Our reference: P-1060893-K2Y4
Contact: Sandra Fagan
Telephone: (02) 4732 7992

**Council Response to Submissions - SSD-81434988- Alspec Warehousing
(High-Bay) Facility at 221-235 Luddenham Road, Orchard Hills, NSW, 2748**

Appendix B Swept path diagram

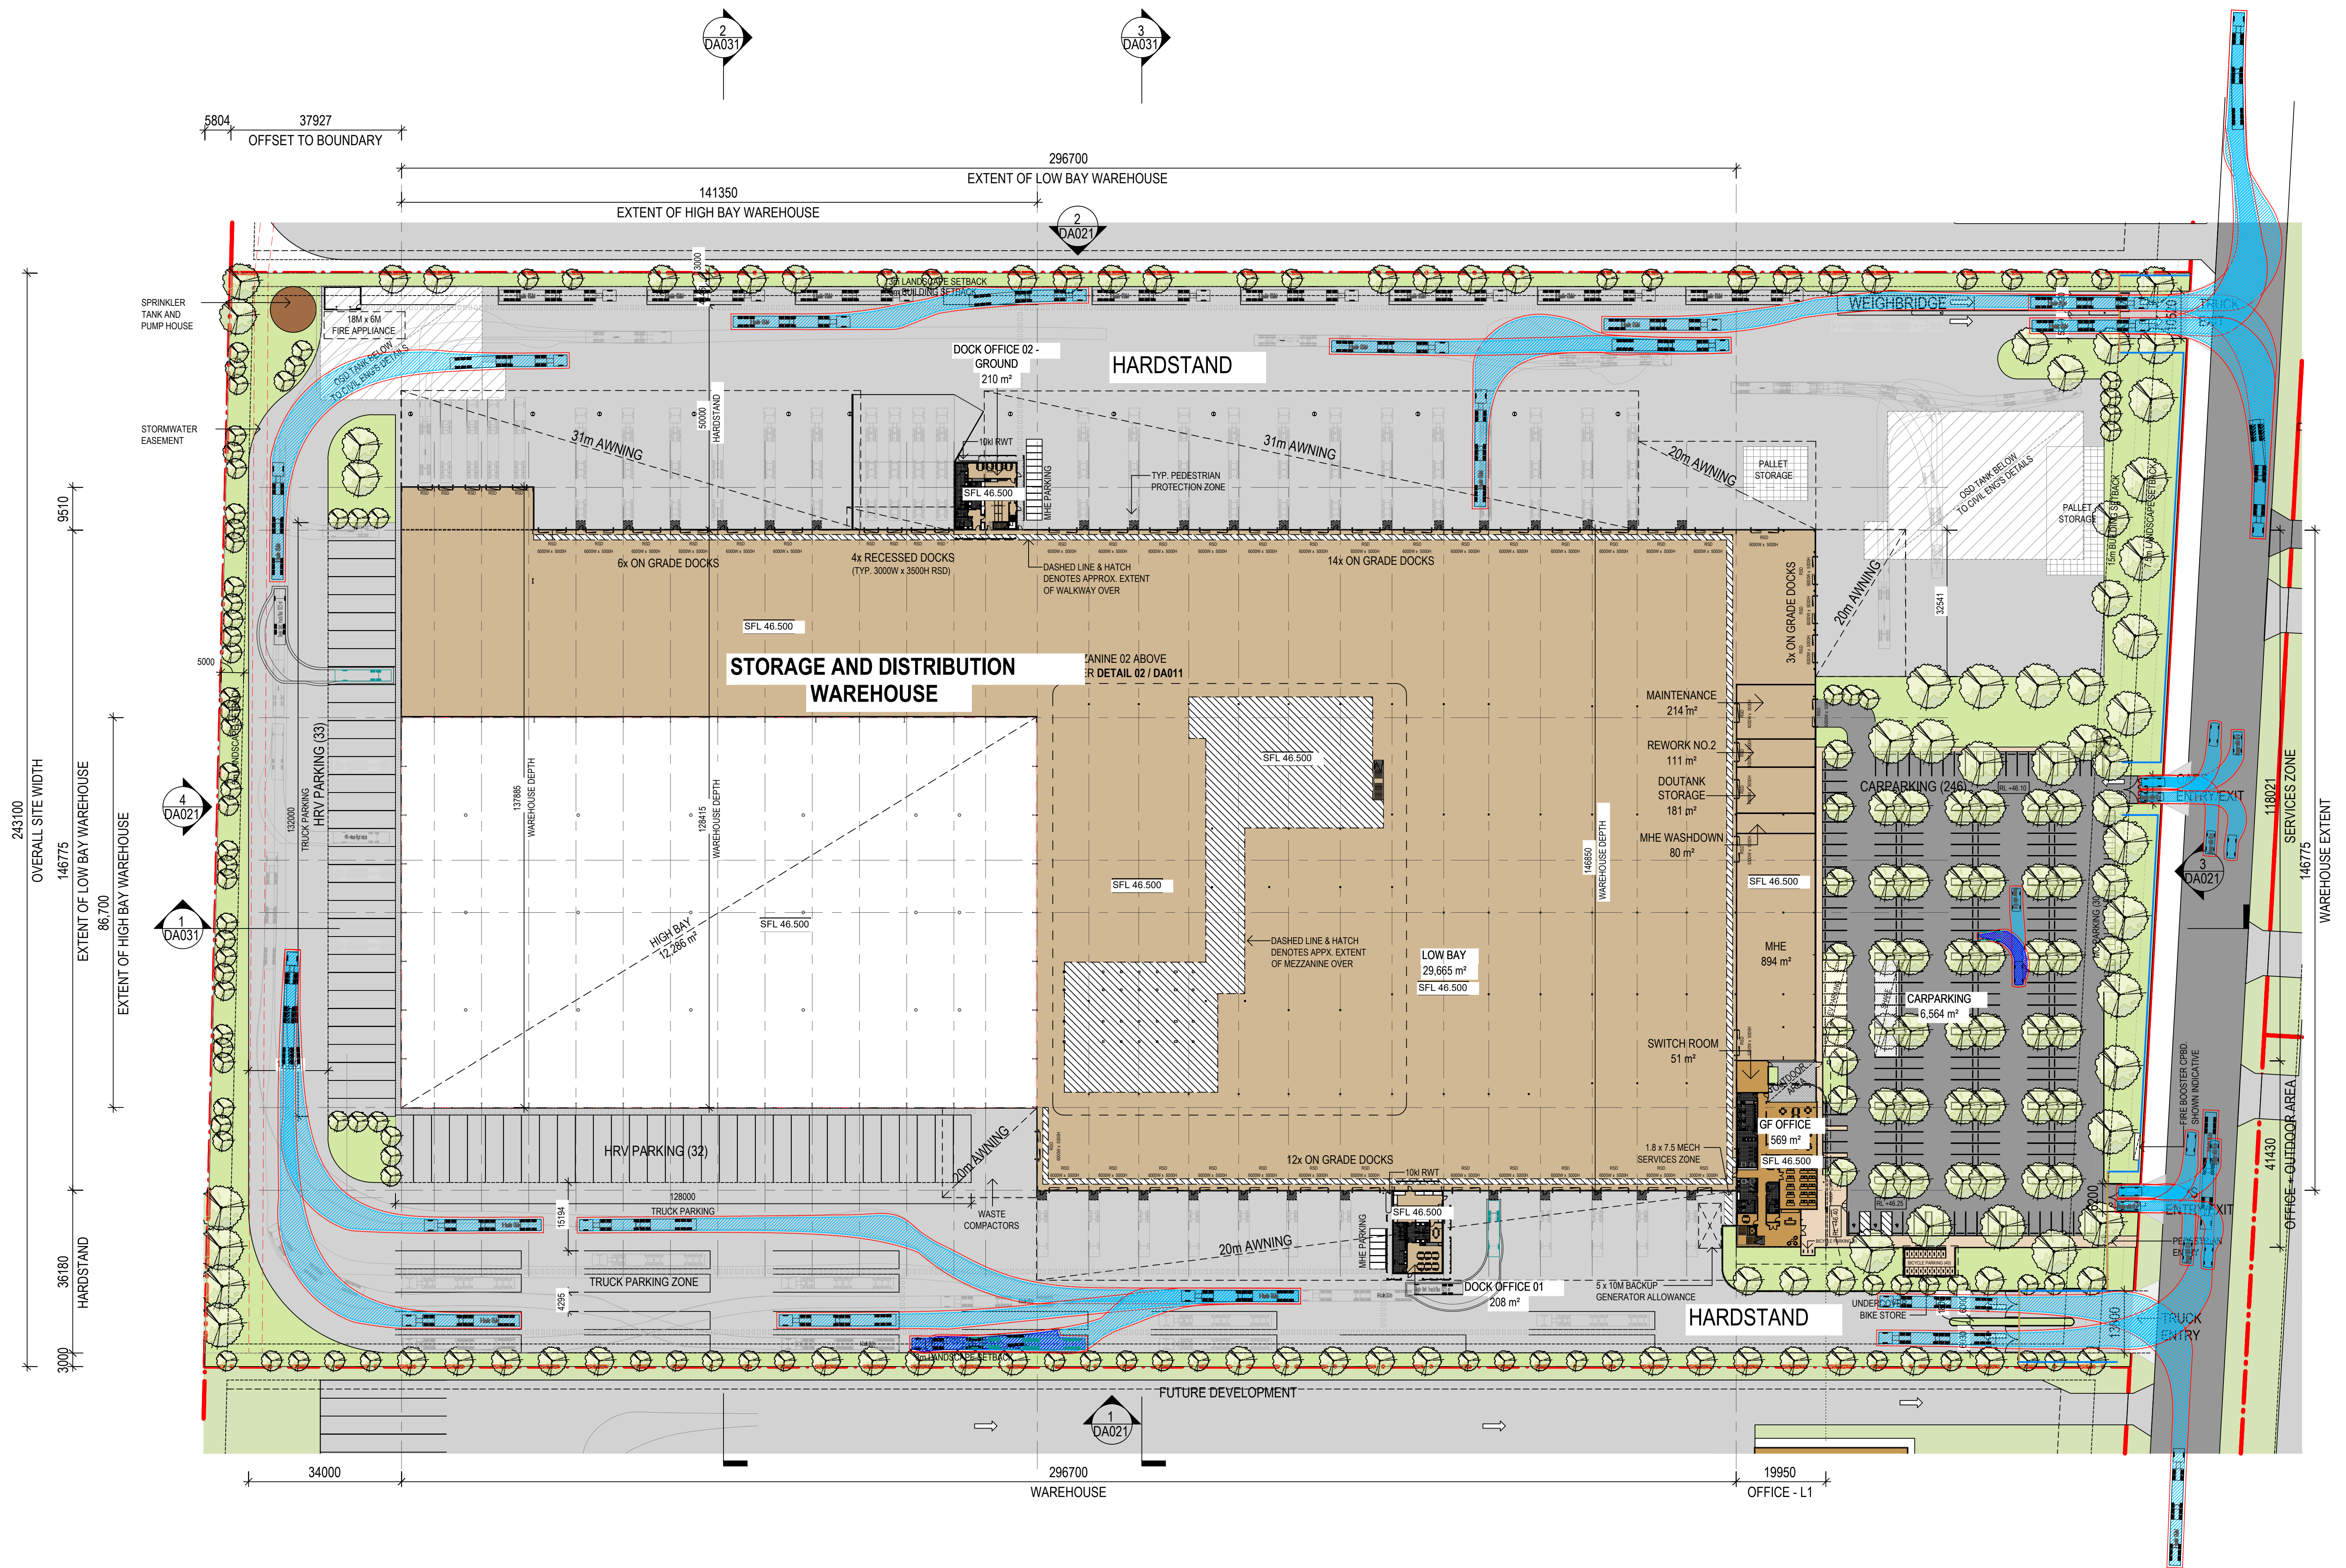
- a) Insufficient swept paths are provided showing the feasibility of heavy vehicle parking on various locations of the site (e.g. HRV swept paths on the west side of the site and parallel parking on various locations).
- b) Egress swept paths also show the vehicle is not contained within the driveway in exiting and may encroach fences and on-street parked vehicles.
